J.S. THOMPSON
ENGINEERING, INC

July 19, 2024

The plan was reviewed for lot #26 Tobacco Road subdivision in Angier, North Carolina to address the girder truss above bedroom #2.

S-3e
ATTIC FLOOR
FRAMING PLAN

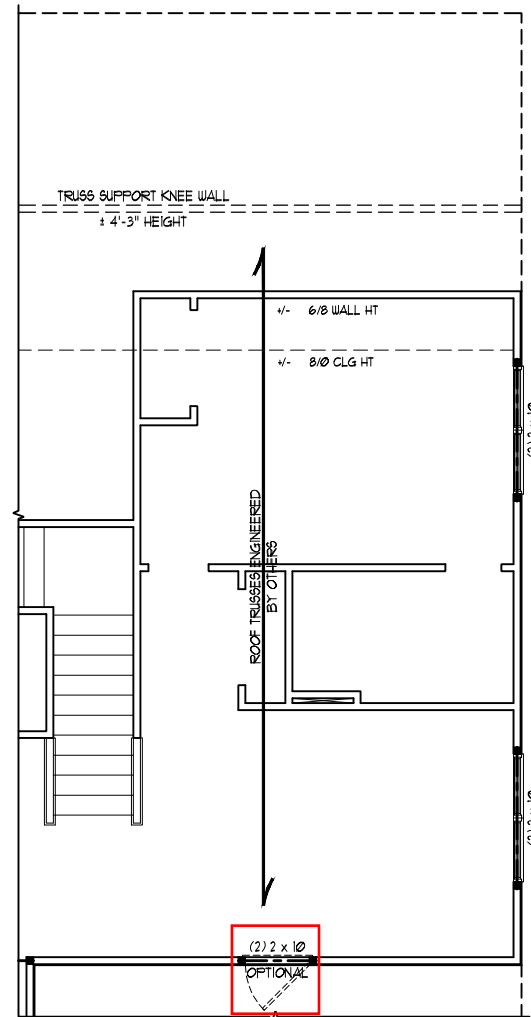
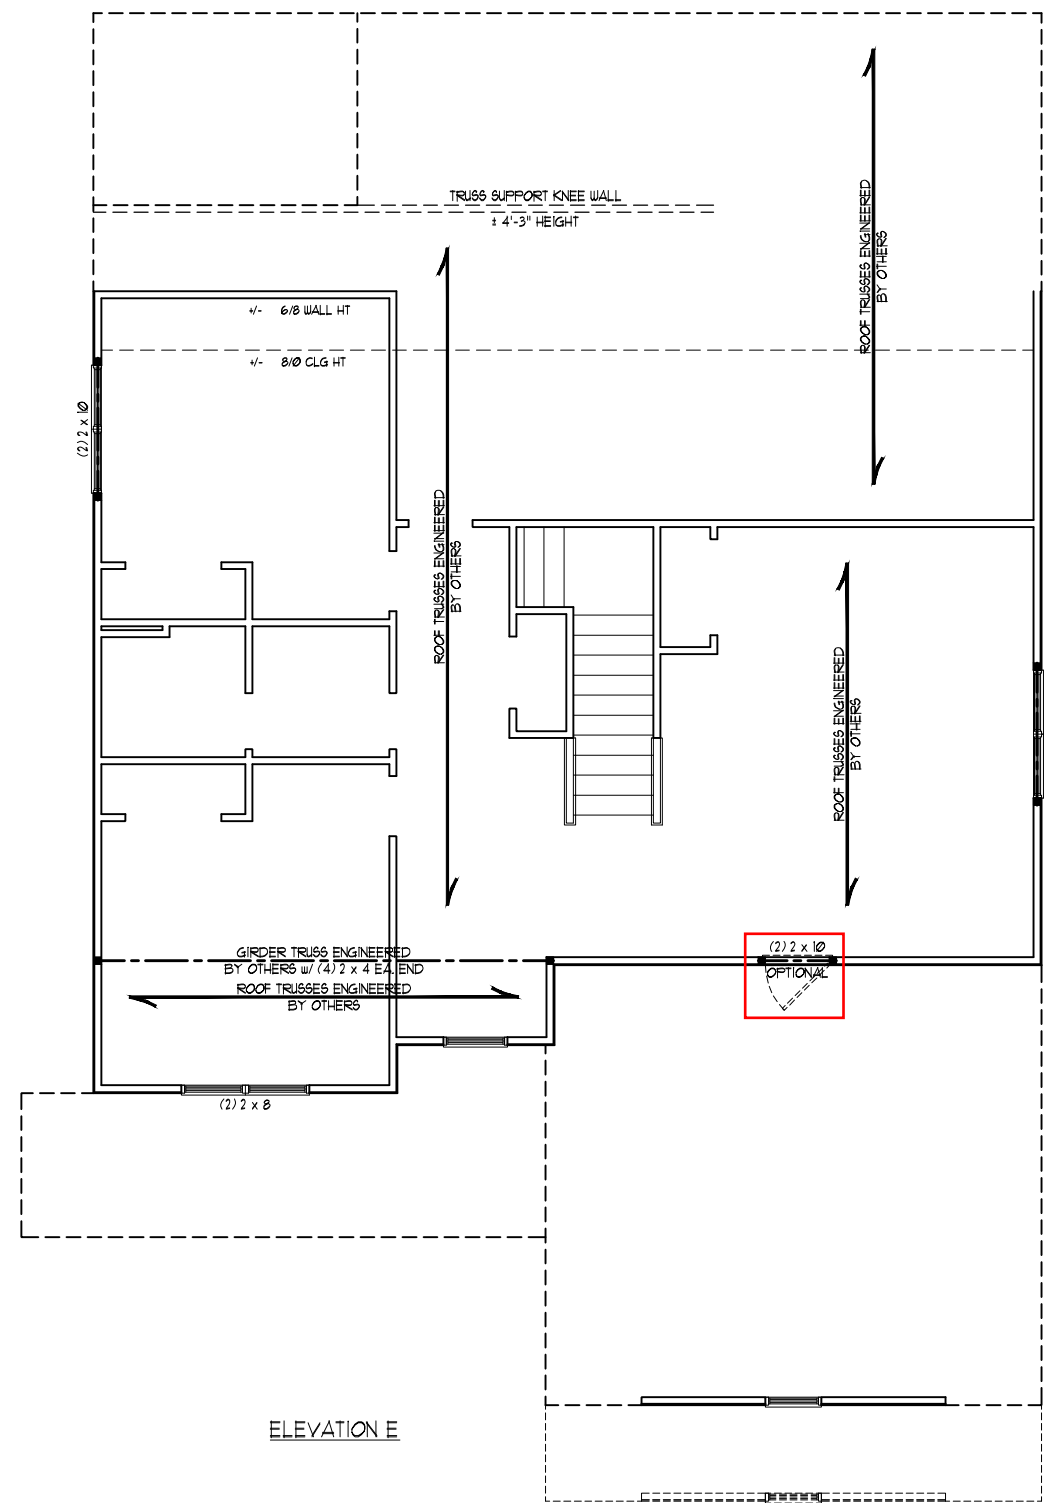
The D3G girder truss above bedroom #2 lacks bearing at the front loft wall. A 2 x 6 x 8'-0" SPF #2 scab is to be installed on the front of the truss to have full bearing on the wall. The scab is to be fastened to the bottom chord with (2) rows of 12d nails at 4" o.c. and (1) row of 4" long Simpson SDS screws at 12" o.c. staggered. Locate screws a minimum of 1 1/2" from the top and bottom edges of the bottom chord/scab. This configuration will provide the required support for all applied loads.
